Re: Marriott Hotel As-built and Drainage Improvements (File No. J-18-D1).

Re: Marriott Hotel As-built and Drainage Improvements
Dated 8/82 (File No. J-18D)

Re: Marriott Hotel site as-built and drainage improvements

MAR. 9, 1981
RTS 7484 SITE GRADING PLAN 0-2

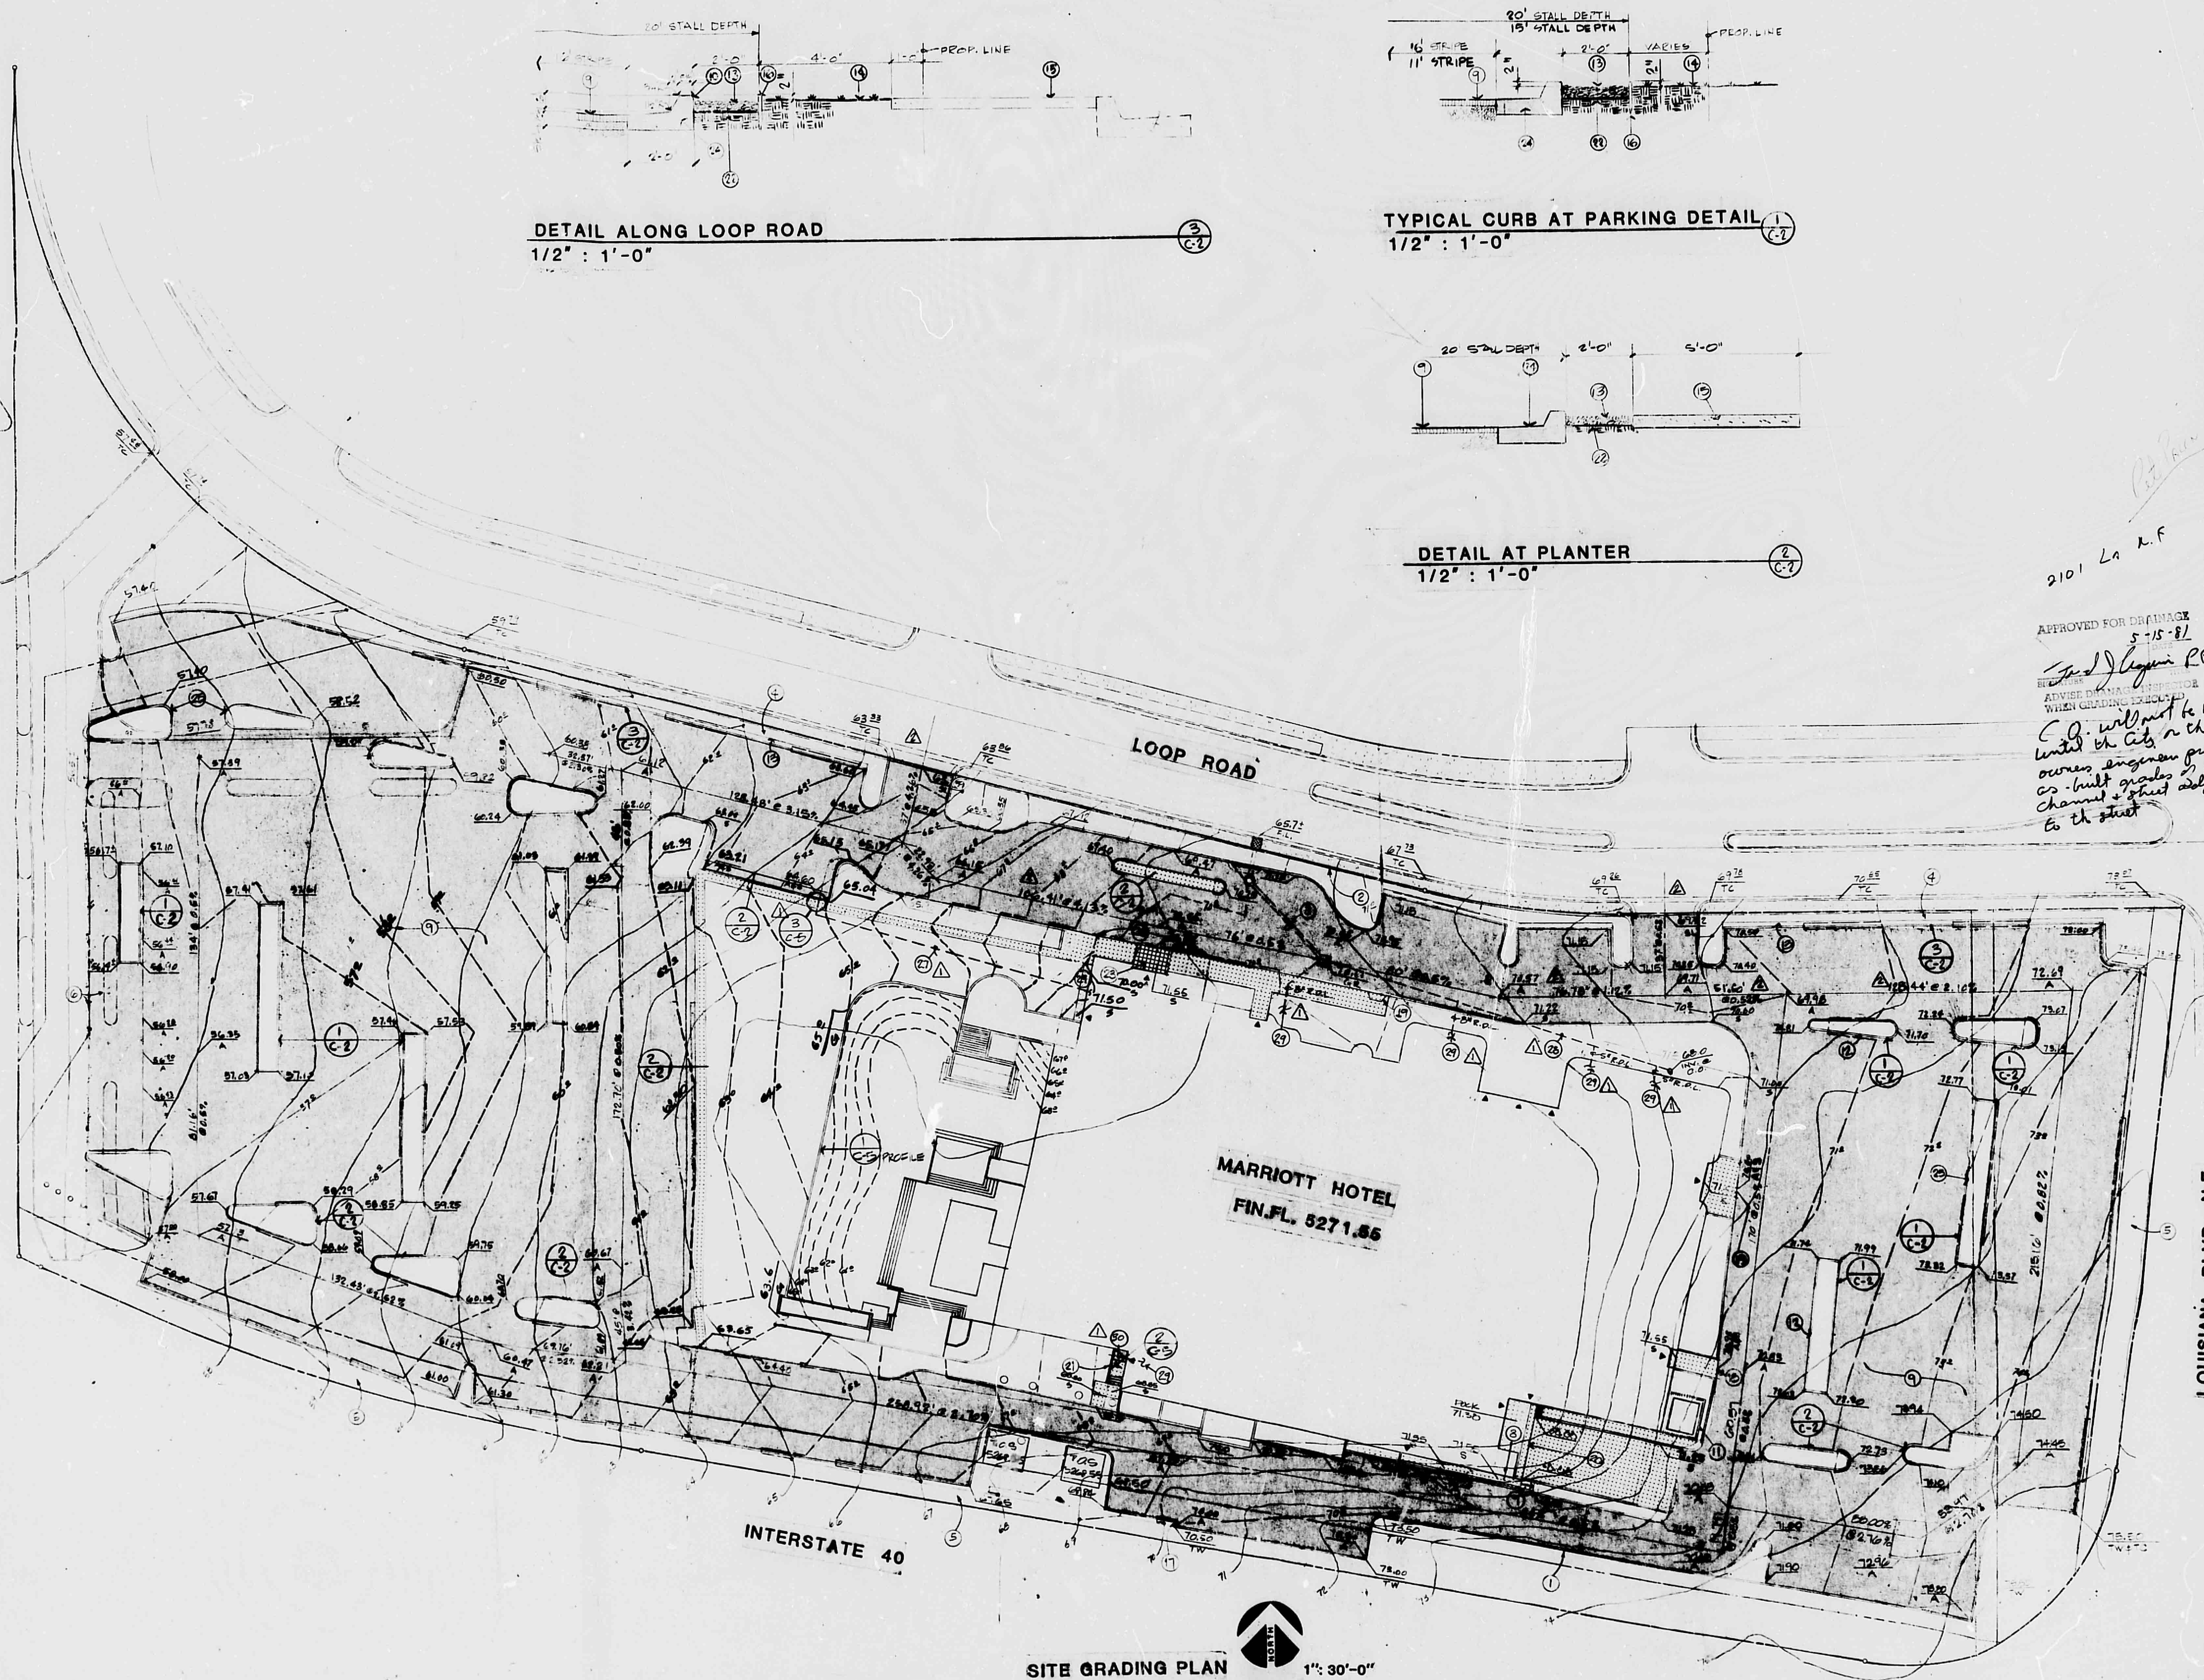
legend unclear as to what applies to what, see plan for detail

- ✓ 1) direction of roof drainage including canals, gutters, and downspouts. *Drain all roof runoff away from structure*
- 2) outlined contributory drainage areas, including roof areas.
- 3) swales with top and bottom spot elevations.
- 4) curb and sidewalk spot elevations.
- 5) flow lines with arrows and spot elevations for

C) *Designated "CFS" entering onto the drainage structure at west end.*
If ponding is required the drainage plan must also

- E) A discussion of any other local conditions that effect site drainage should be included.
- ✓ F) Details of ponds, curbcuts, water blocks, and any other significant drainage structures must be included.
include detail from sheet C-5 on sheet C-2

Please find attached the as-built of the Marriott along with the hydrological calculations at the various stations which correspond to the sections analyzed in the original drainage report for Park Square. It can be seen that Loop Rd. will carry the design flow (120 cfs from the Master Drainage Study) except for the area of the driveway at Station 9+80 where a large portion of the design flow would enter the Cinema I,II,III parking lot and run west. As a proposed solution to this problem, we have called for an asphalt berm to be constructed through the driveway to turn the water south into the drainage swale (See attached drawing).

The water at Station 9+05 must turn almost 90°, therefore the water must back up at that point. The energy grade line at Station 9+05 is elev. 58.05, therefore the maximum high water at that point was considered to be 58.00. It can be seen that the existing walls at Station 9+05 will direct most of the flow down the street but there will be some flow through landscaped areas in the area of Station 9+55, and at design flow some plantings may be lost, but the owner is aware of this potential problem and considers it to be a minor problem.

The energy grade line at Station 9+80 is elev. 57.61 and the top of the proposed berm to be elev. 57.85, which should contain the flow even in the event of a hydraulic jump at that point.

The As-built Plan with the proposed improvements for the referenced site is approved.
